Recommendation Report for Planning Permission

REF NO: LU/284/20/PL

LOCATION: 54 Arundel Road
Littlehampton
BN17 7DD

PROPOSAL: Demolition of 3 No. garages & erection of a four-room house of multiple occupation with shared facilities & parking for 3 cars (resubmission of LU/125/19/PL).

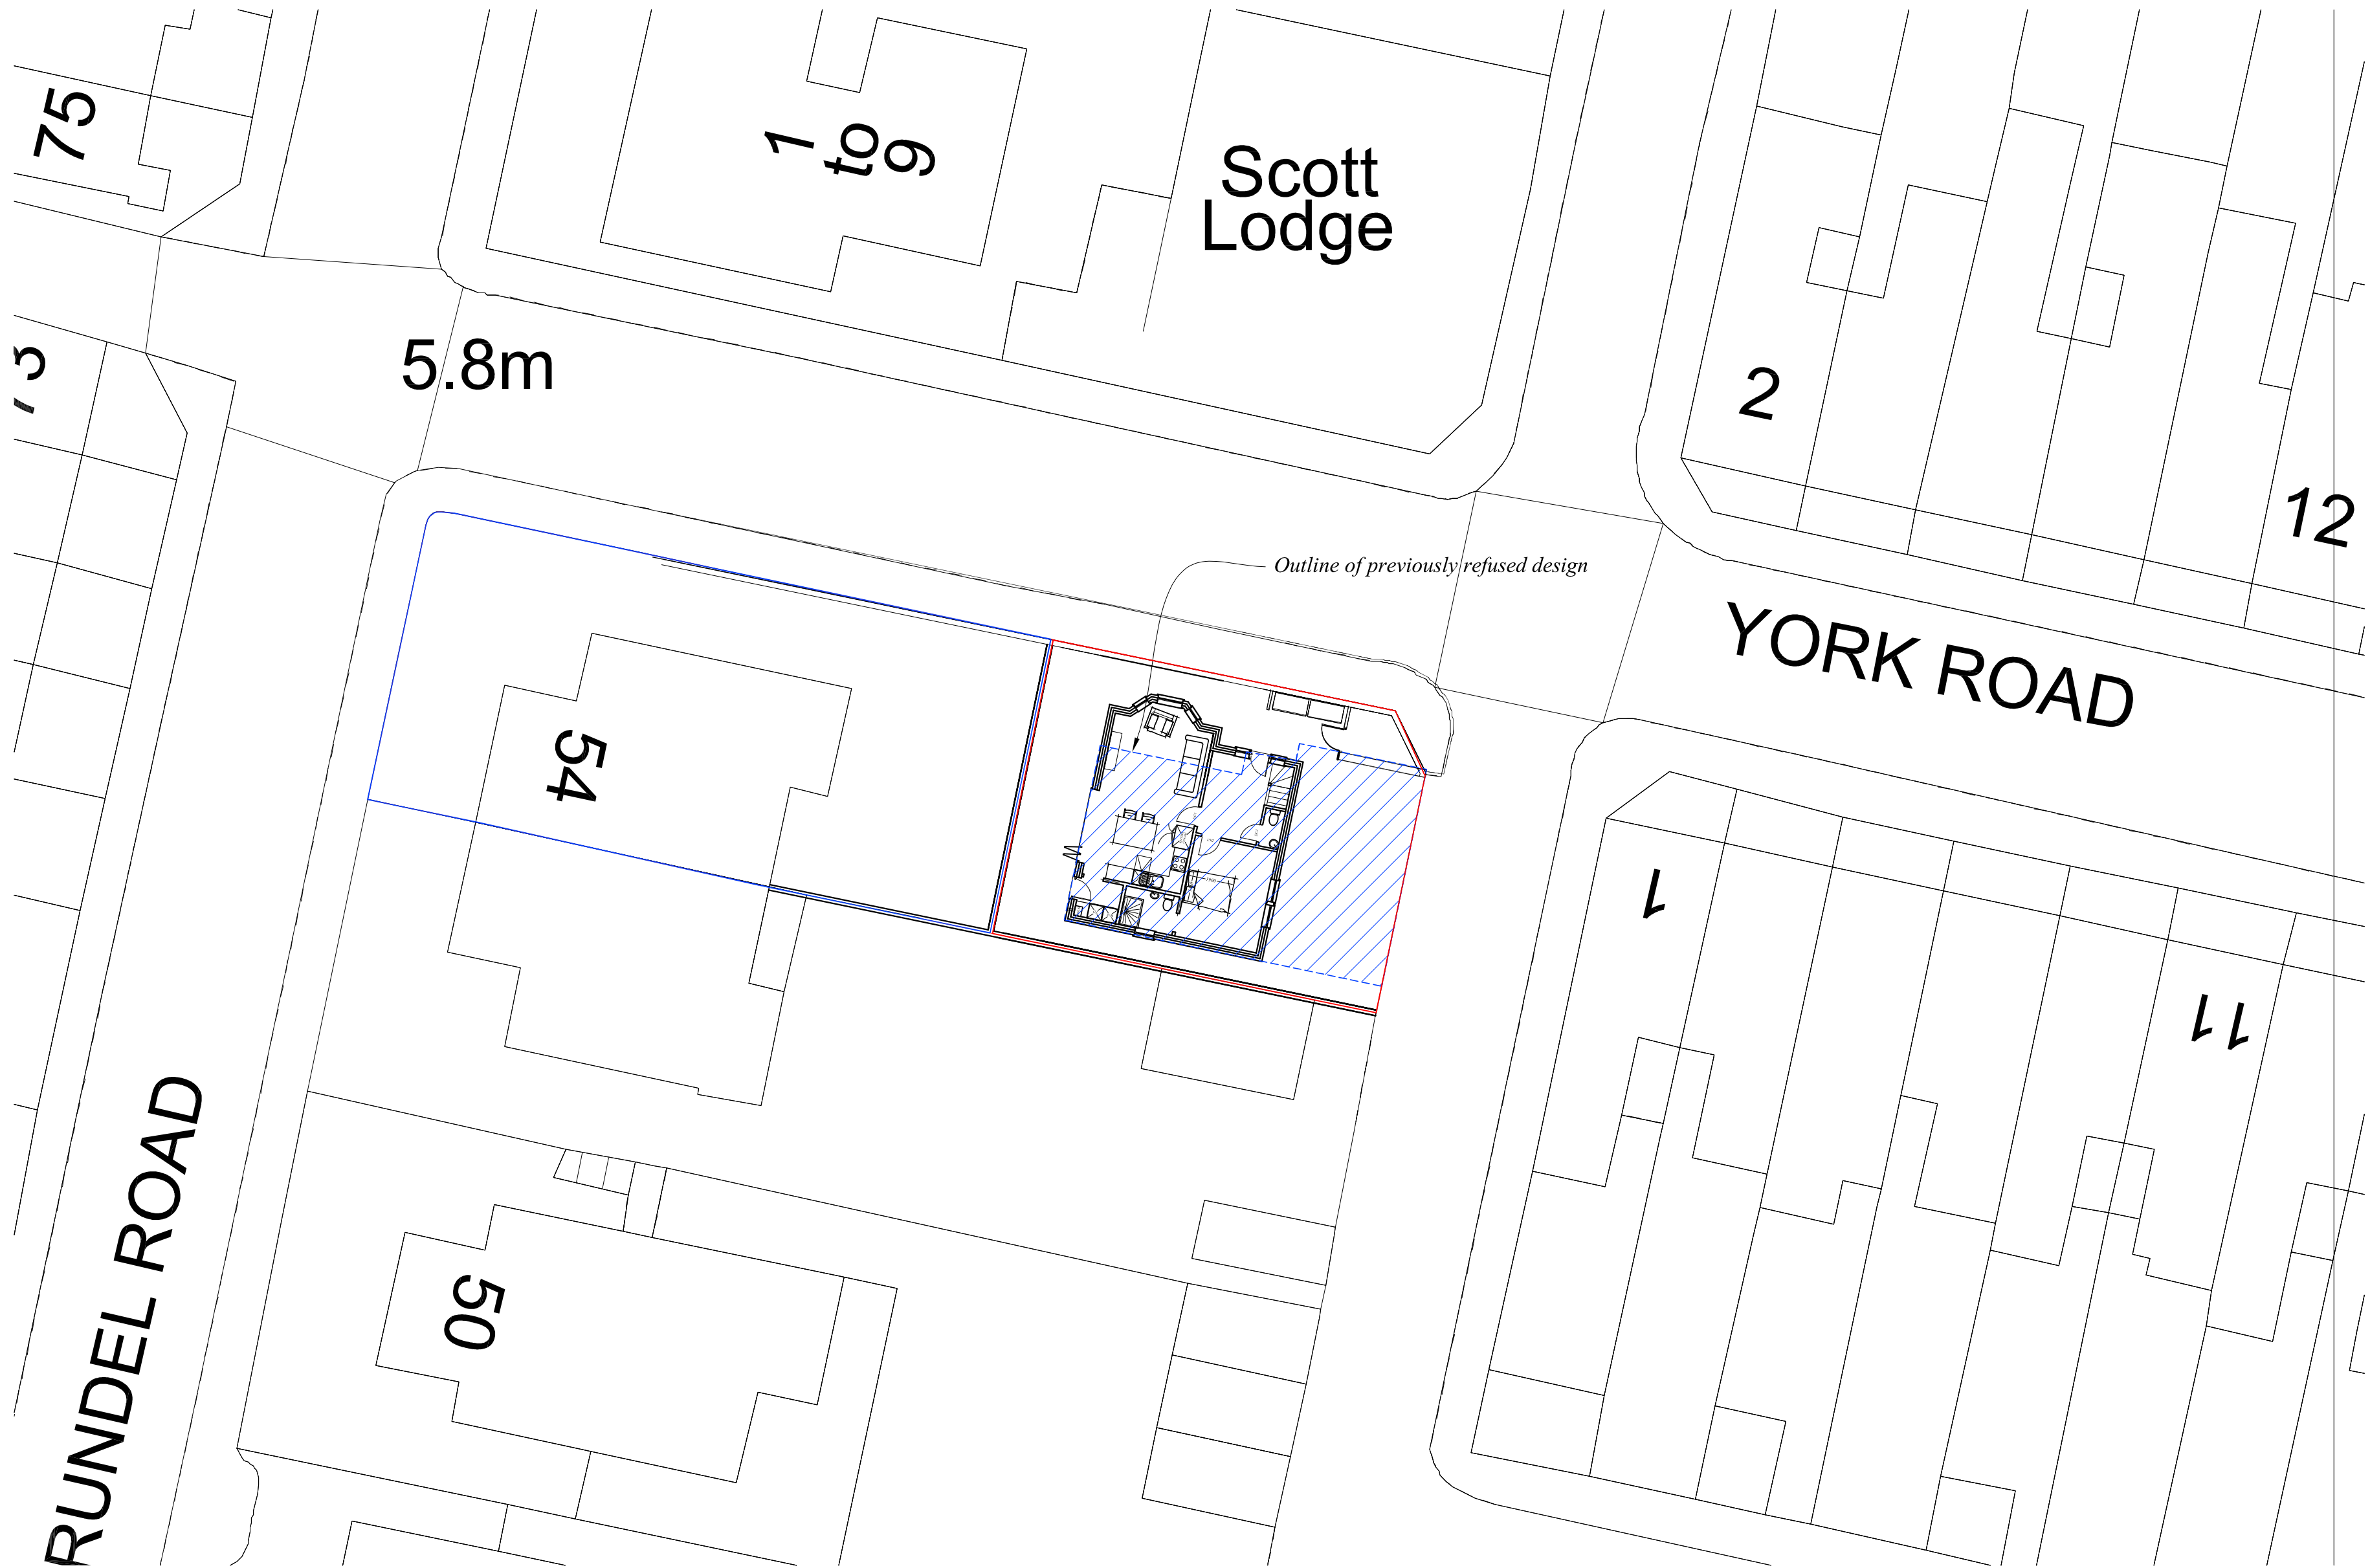
The neighbours at 1 York Road to the rear have facing windows at ground and first floor levels including sole windows to bedrooms at first floor level. The separation distance of 12 metres to bedroom windows at the new property would lead to a loss of privacy. A distance of 20 metres between primary habitable room windows would normally be expected.

The Arun Design Guide requires that a 4 bedroomed house should provide a 10.5 metre back garden the width of the house. In this case a 2.8 metre strip is provided to the west of the property which is not enough to provide adequate outdoor amenity space for the intended occupiers.
